Your Ref: SSD-9601

SSD-9601 – 780 WALLGROVE ROAD, HORSLEY PARK – PROPOSED UPGRADES TO PLANT 2 – RESPONSE TO SUBMISSION

ATTACHMENT A – DEVELOPMENT ENGINEER CONDITIONS

B-Double (26.0m)  
Overall Length 26.000m  
Overall Width 2.500m  
Overall Body Height 4.300m  
Min Body Ground Clearance 0.540m  
Track Width 2.500m  
Lock-to-lock time 6.00s  
Curb to Curb Turning Radius 15.000m  
Design Speed 10km/hr

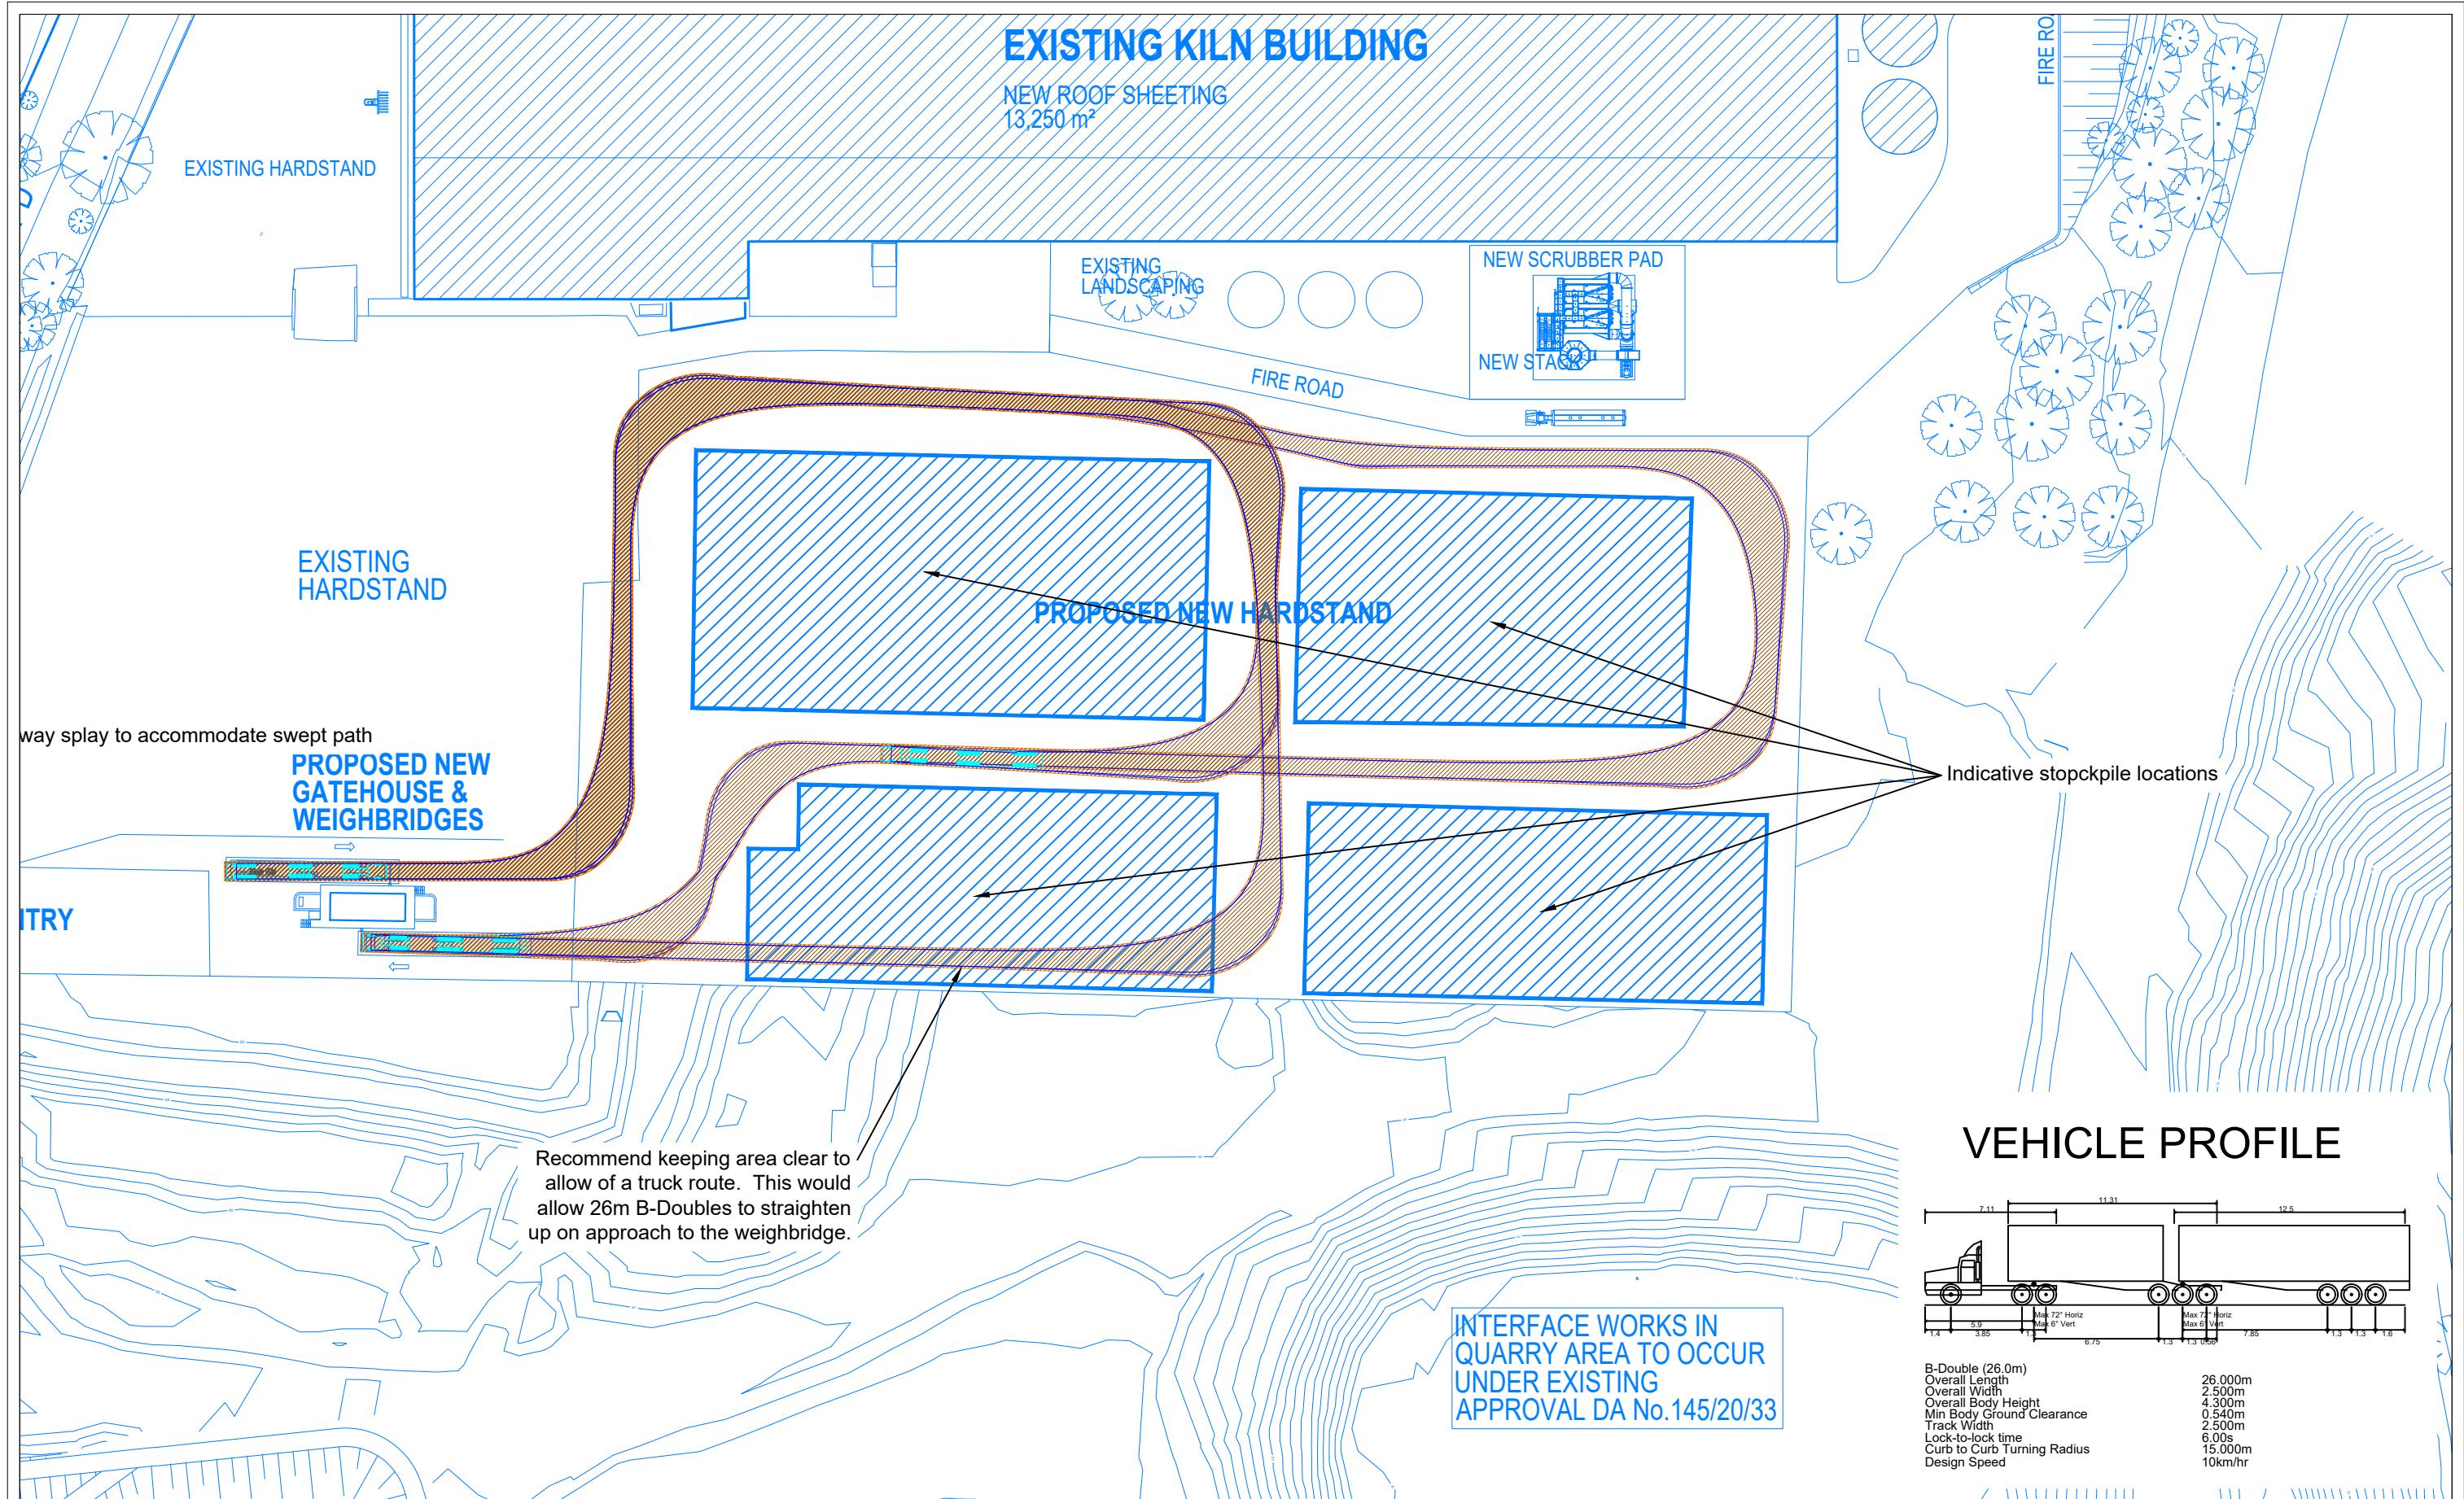
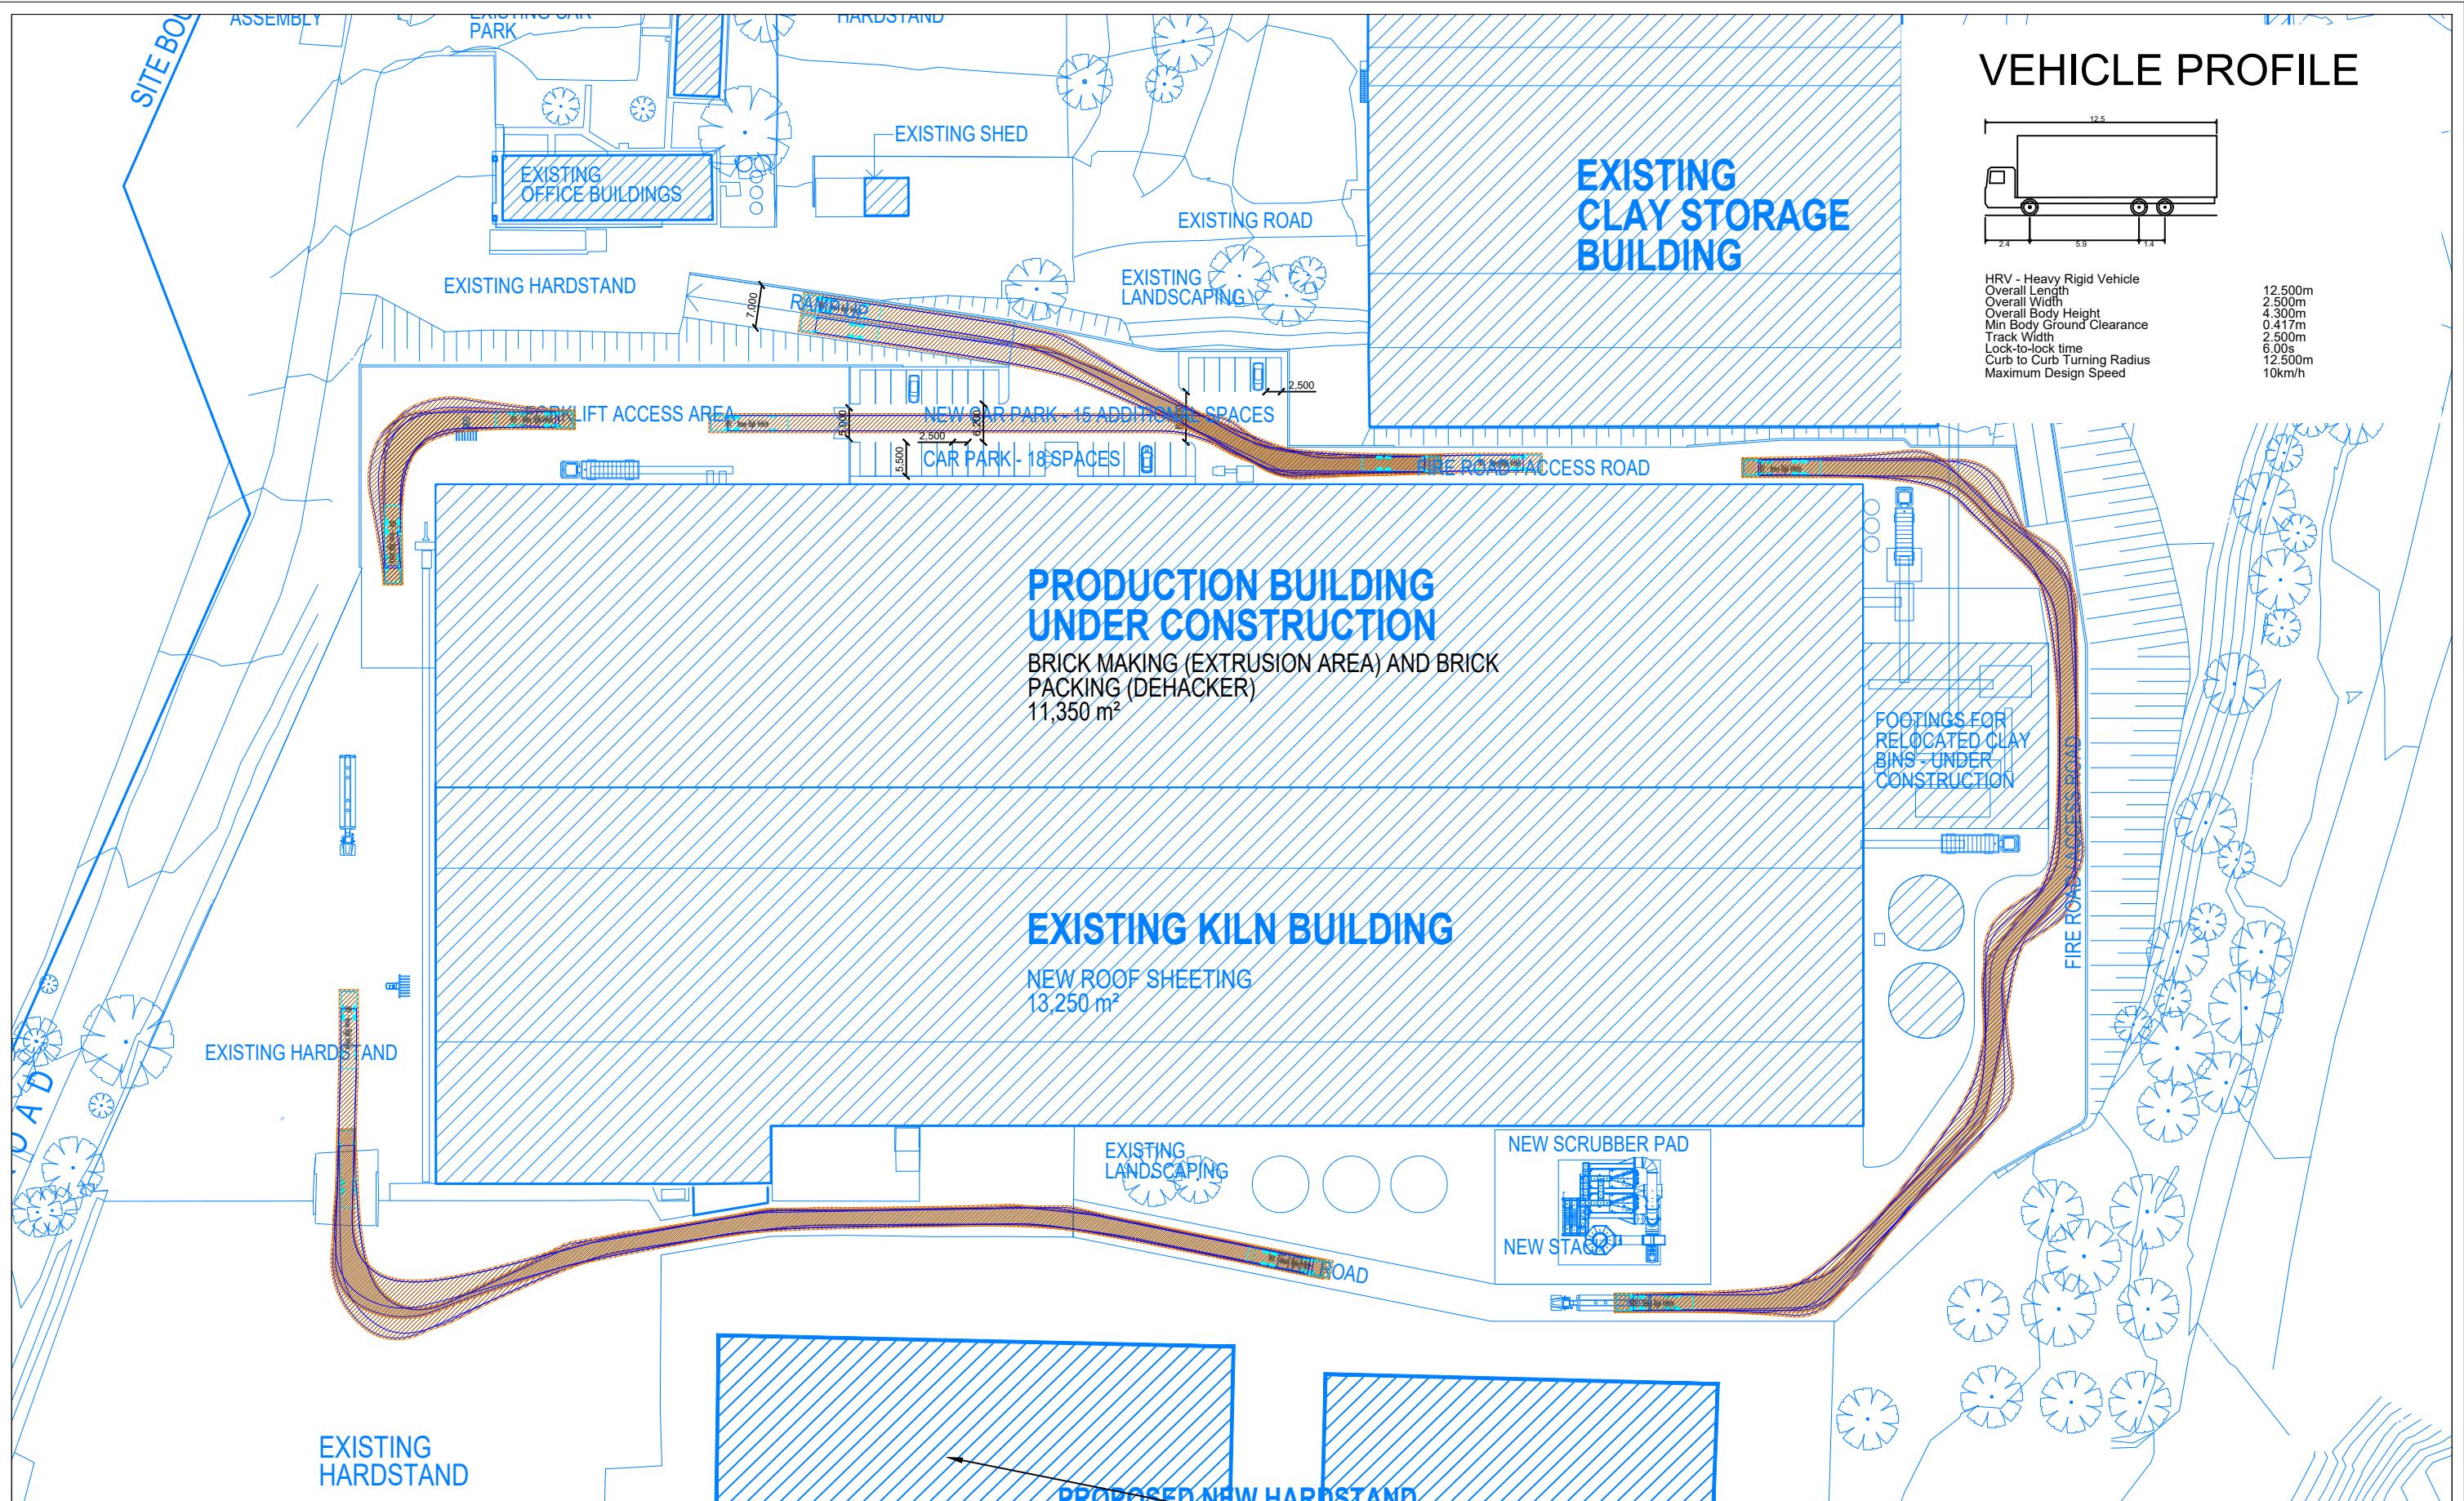
The proponent previously indicated that the largest vehicle servicing the subject site is a 26m B-Double vehicle. To ensure the servicing vehicle will not obstruct car parking areas and flow of traffic within the site, the proponent shall submit a turning path analysis showing the largest vehicle (26m B-Double vehicle) manoeuvring into, within and out of the site shall be submitted to Council for assessment.

The largest vehicle (26m B-Double vehicle) shall carry out loading and unloading activities from the designated loading areas and shall not obstruct car parking areas and the flow of traffic within the site.

Council requires further clarification regarding where the 26m B-Double vehicles will carry out loading and unloading activities on-site, with details to be submitted to Council's satisfaction prior to the commencement of construction activities.
